From: [REDACTED]  
To: [REDACTED]  
Subject: FW: Additional information required for 22/00977/F  
Date: 22 July 2022 14:36:43  
Attachments: Top View - Rose Lodge - 59 Barroway Drove.pdf  
Location Plan Rose Lodge 59 Barroway Drove.pdf  
Block Plan Rose Lodge 59 Barroway Drove.pdf  
Landmark Envirosearch Residential.pdf.pdf

From: Andy Derrick [REDACTED]  
Sent: 21 July 2022 [REDACTED]  
To: Borough Planning <[borough.planning@West-Norfolk.gov.uk](mailto:borough.planning@West-Norfolk.gov.uk)>  
Subject: Re: Additional information required for 22/00977/F

Rose Lodge, 59 Barroway Drove

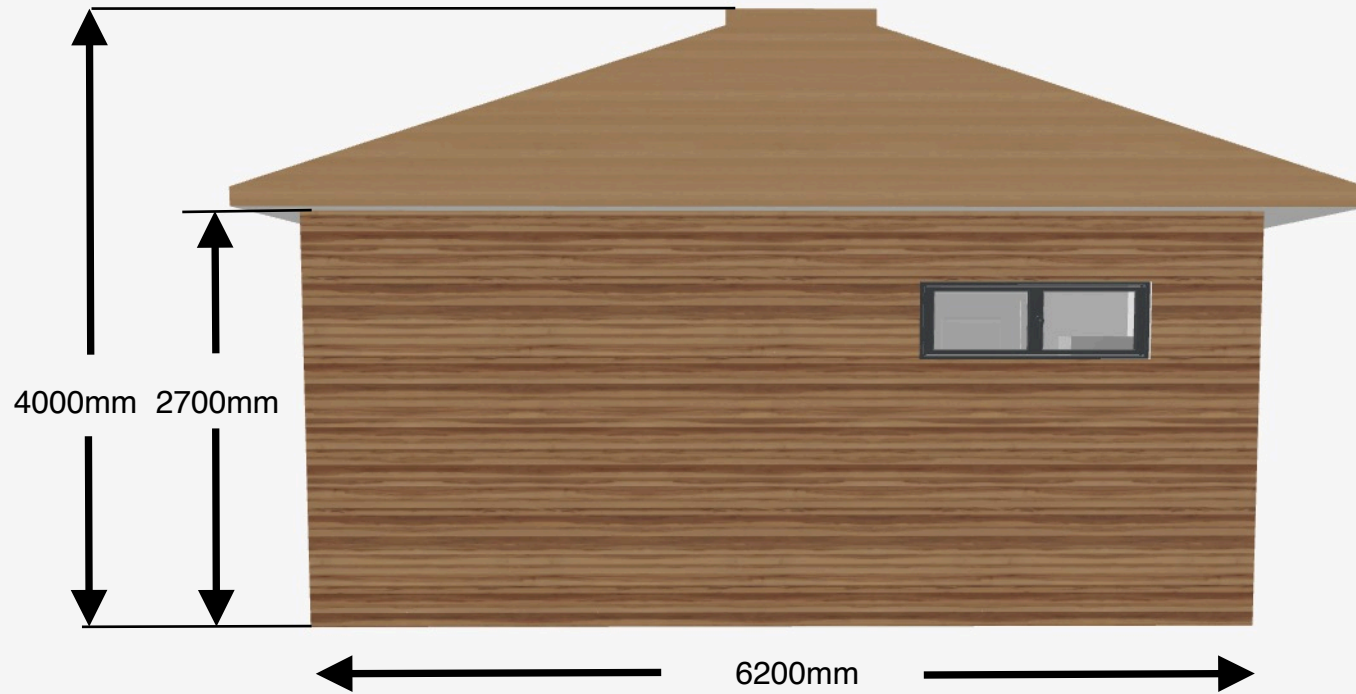
It appears that the Floor plan was missing from the attached, please supply drawing to scale of either 1:50 or 1:100. - **Attached**
